VA-22-00004 Pemsel
Setback Variance

TO: All Staff
FROM: Public Works Plan Review Team
DATE: September 19, 2022
SUBJECT: VA-22-00004 Pemsel

RE: VA-22-00004 (Pemsel)

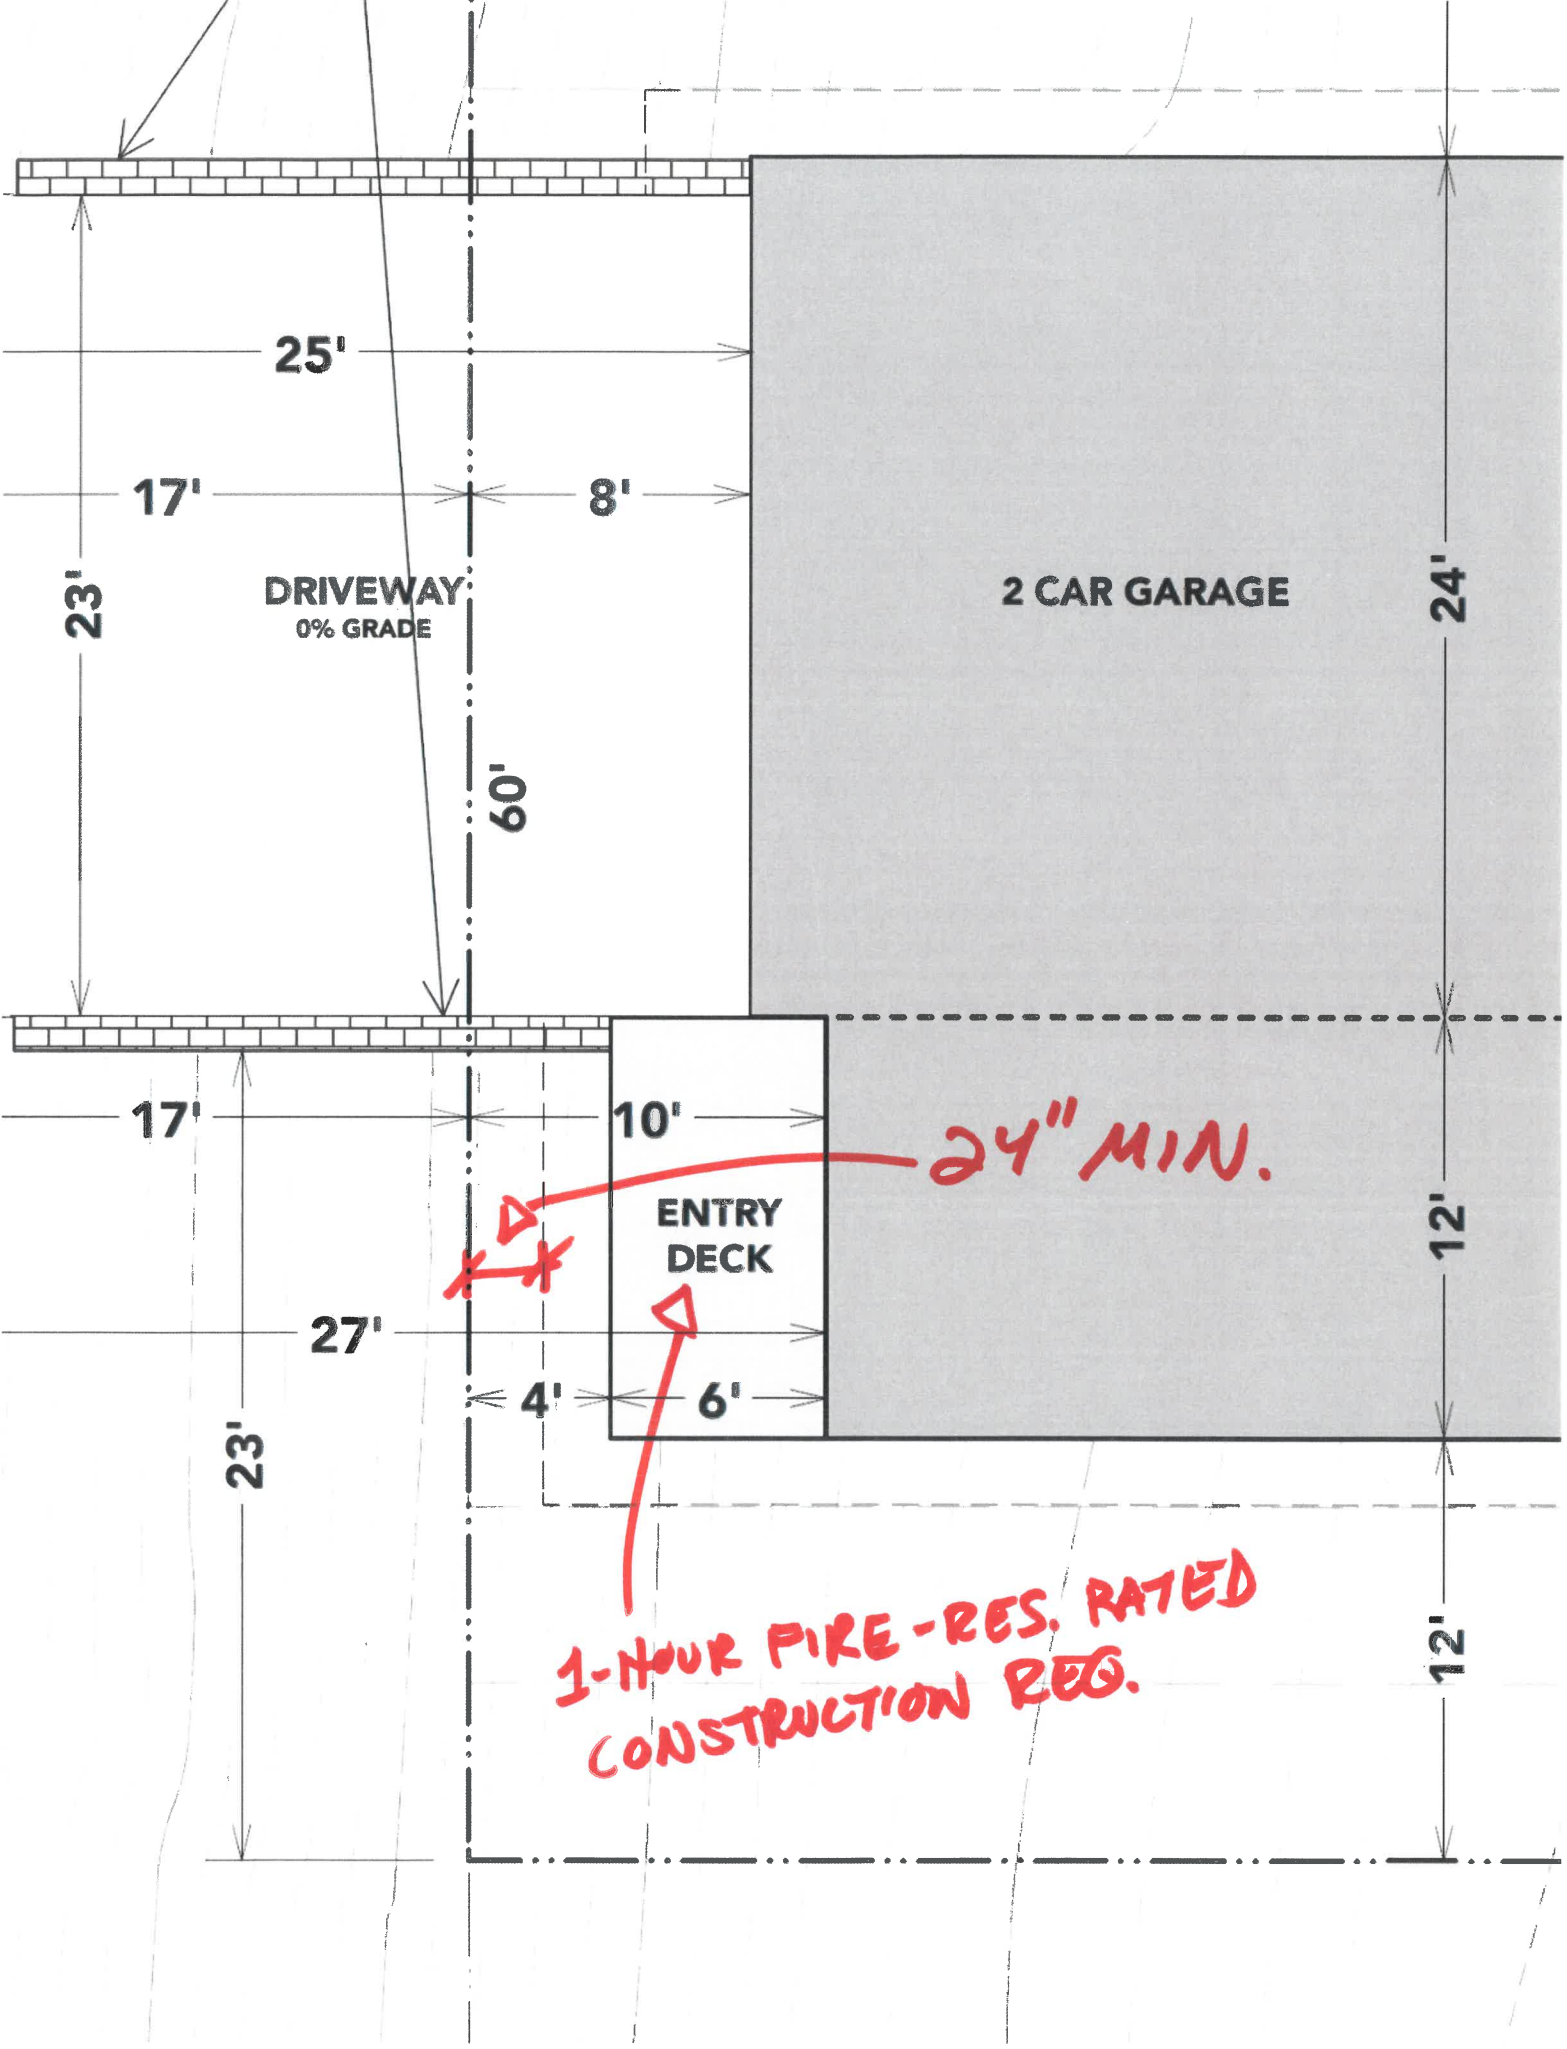
ACCESS	1. No Access Comments (TM)
ENGINEERING (CC)	<ol style="list-style-type: none"> 1. Unusual hazardous slopes in the area will require any grading performed on site be done under an Engineered Grading Permit. Please contact Public Works for instructions on how to procure this permit. 2. It may be the case that Public Works requires additional mitigation within the Clear Zone (10ft from edge of pavement). Public Works may impose some limitations on the type of retaining wall used within the Right of Way, such as preventing the use of “pour in place” or “precast” structures. 3. Be aware that Maintenance of Hyak during winter months may require snow be blown towards the edge of the county Right of Way. Public Works recommends limiting the setback variance to 10 feet from the front property line.
SURVEY	No survey comments (JT)
FLOOD & WATER MITIGATION/ METERING	No comments (SC)

*2018 IRC Table R302.1(1) does not allow roof eaves, overhangs or any projections closer than 24 inches to a lot line.

*Exterior walls and projections located less than five (5) feet from a lot line must be one-hour fire-resistant rated. If the structure is provided with automatic sprinklers, walls and projections less than three (3) feet from a lot line must be one-hour fire-resistant rated.
